From: Murphy, Alexander N [<mailto:alexander.murphy@mottmac.com>]
Sent: 15 November 2018 22:12
To: A303 Sparkford to Ilchester
Cc: Hayes, Elliot; Sanderson, Hannah; Paula McGeady; A303 Sparkford to Ilchester Dualling (A303SparkfordtoIlchesterDualling@highwaysengland.co.uk)
Subject: A303 Sparkford to Ilchester - S51 revised documents to PINS.

Please find below a response to the S51 advice together with an FTP site hosting the required files.

Drawing Title
**WORKS PLANS
REGULATION 5(2)(j)
SHEET 3 OF 4**

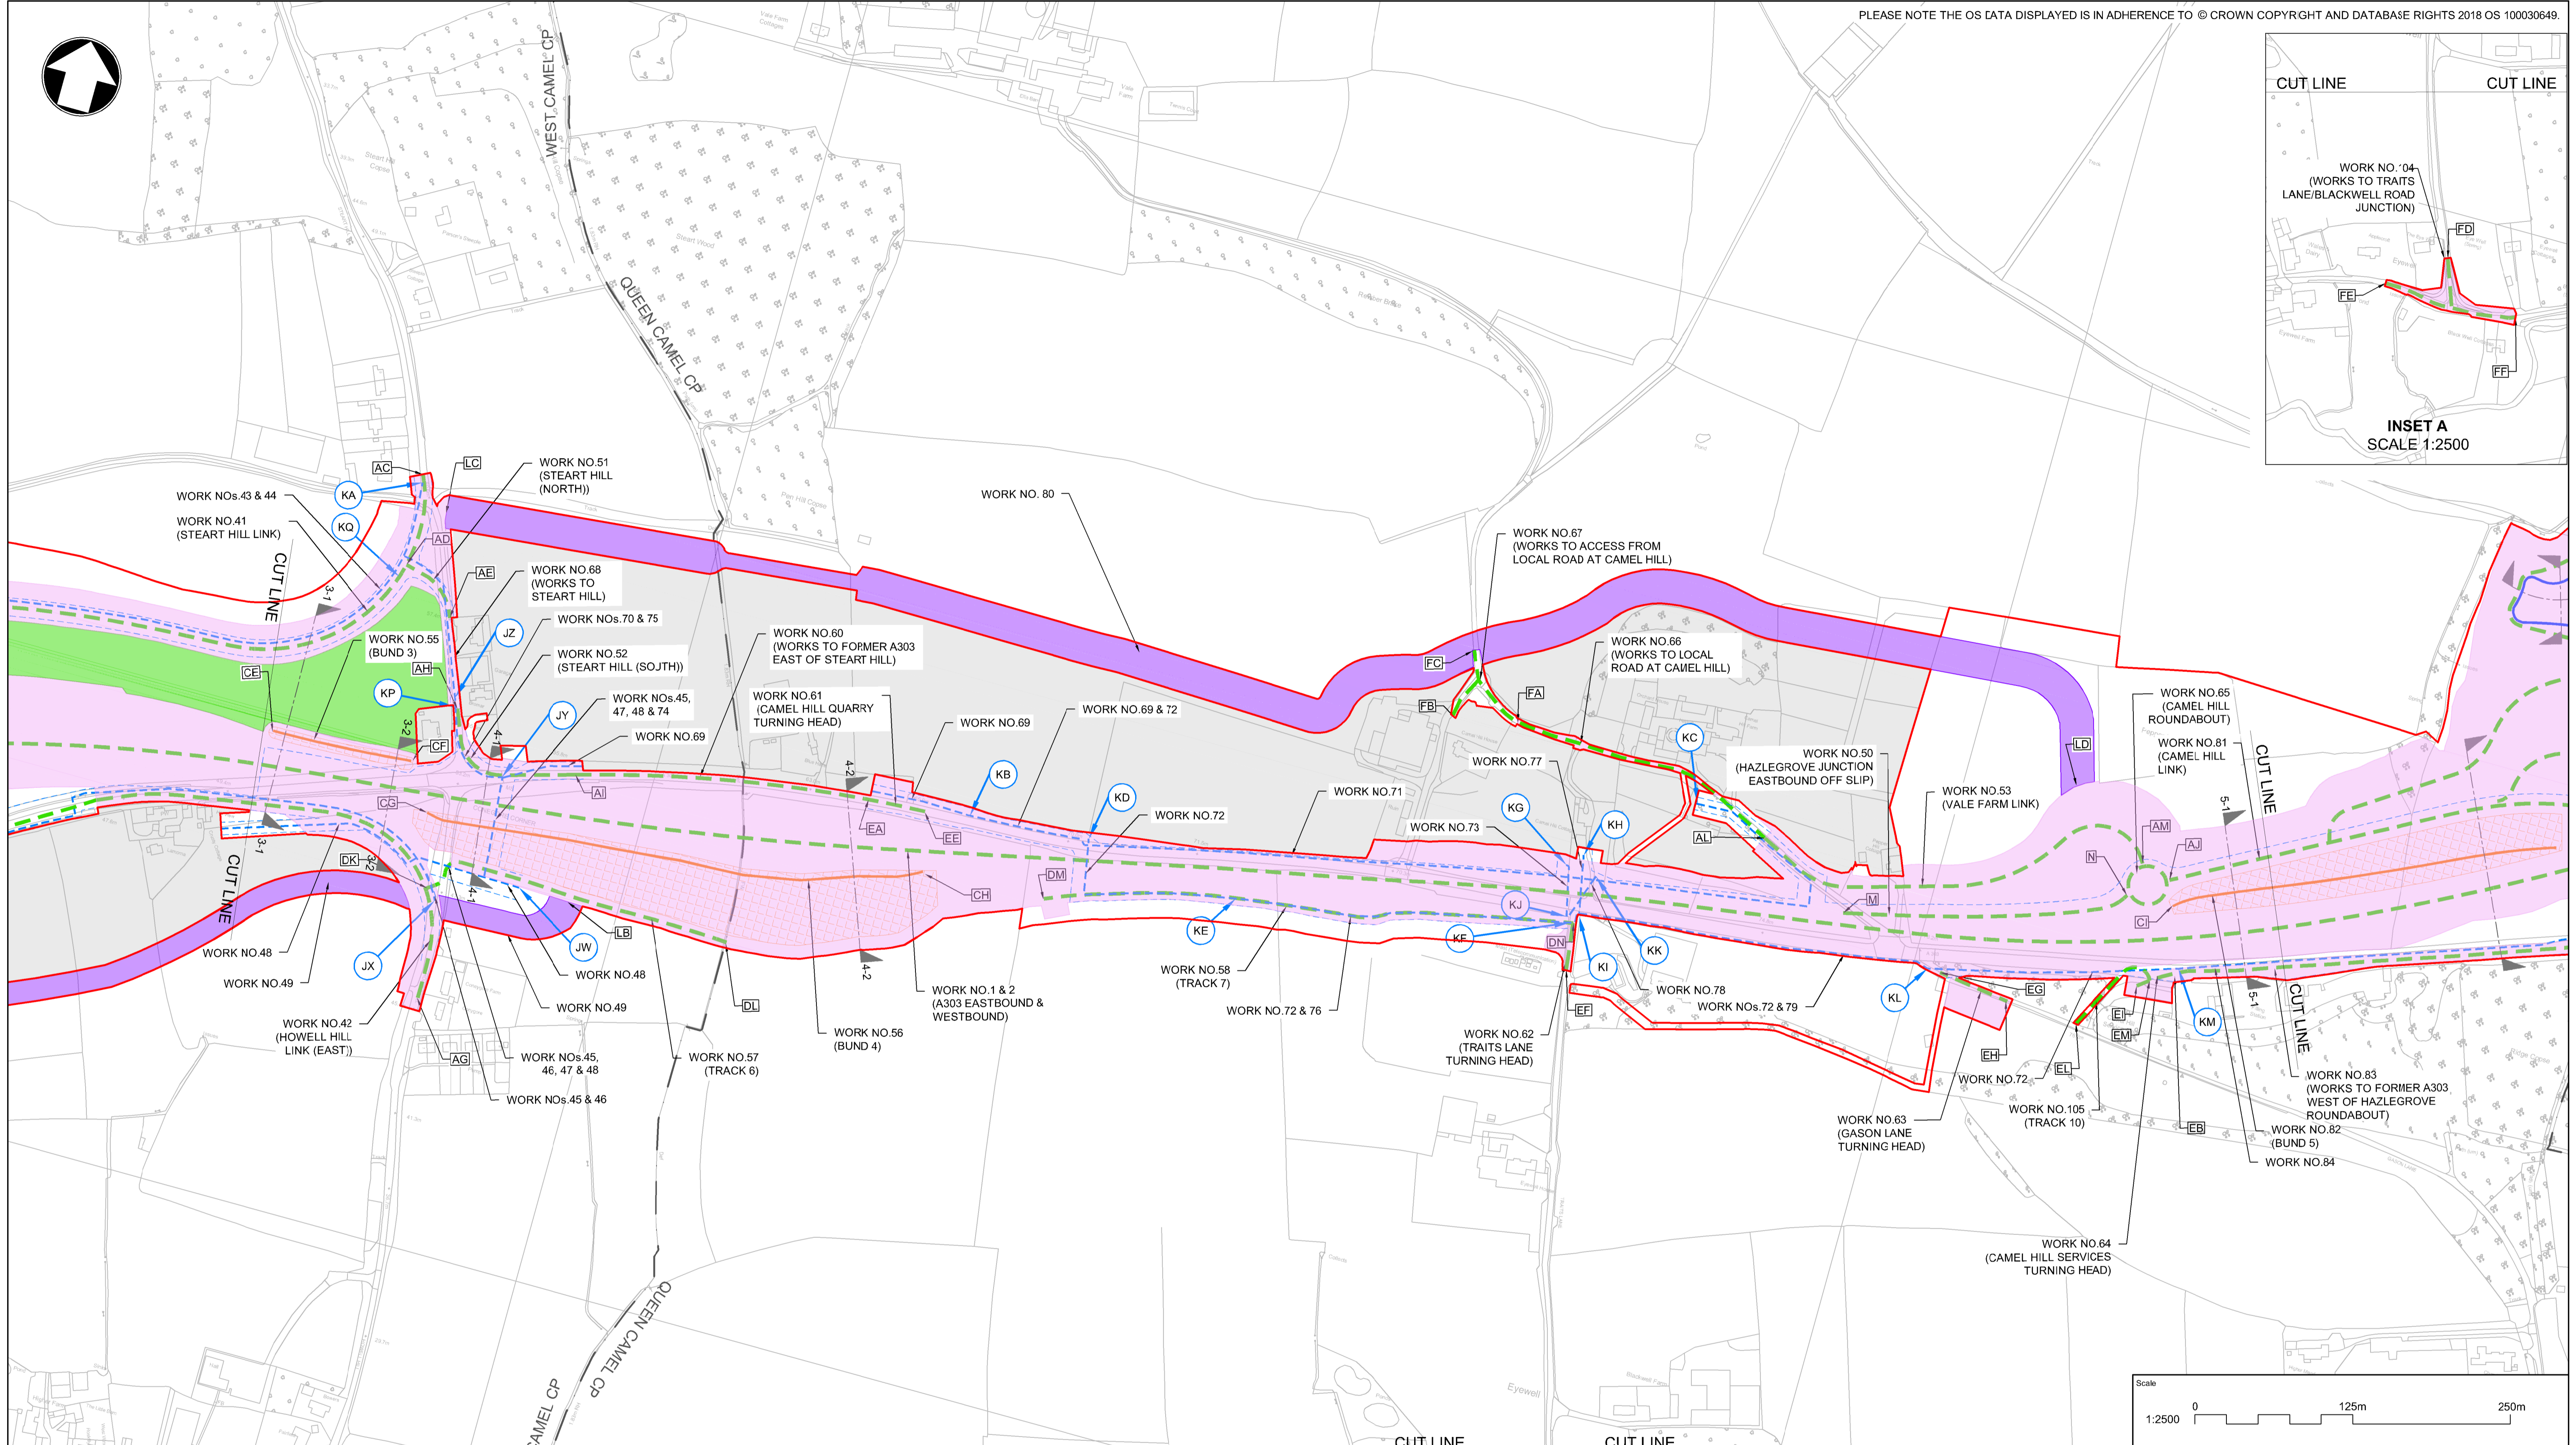
<p>Work No.56 in Schedule 1 of the Draft Development Consent Order (Document 3.1) is described as shown on sheet 3, however sheet 4 also gives a location for Work No. 56 and describes this as "WORKS TO FORMER A303 WEST OF HAZELGROVE ROUNDABOUT".</p>	<p>Accepted. Work No 56 was shown in error on Sheet 4 of the Works Plans. Sheet 4 has been updated with the correct reference, Work No 83.</p>	<p>HE551507-MMSJV-LSI-000-DR-UU-2035 Rev C02</p>
<p>Work No. 68 in Schedule 1 of the Draft Development Consent Order (Document 3.1) is described as shown on sheet 3 between points 'EA' and 'AH'. The Work on the relevant Works Plan (Document 2.3) does not point to this location.</p>	<p>Accepted. The reference to point 'EA' in Schedule 1 is an error. Schedule 1 will be updated with the correct description of Work No 68: "Works to the existing 'Stear Hill', shown on sheet 3 of the Works Plans between points AE and AH. To include: "</p>	<p>Schedule 1 of the Draft Development Consent Order (Document 3.1)</p>
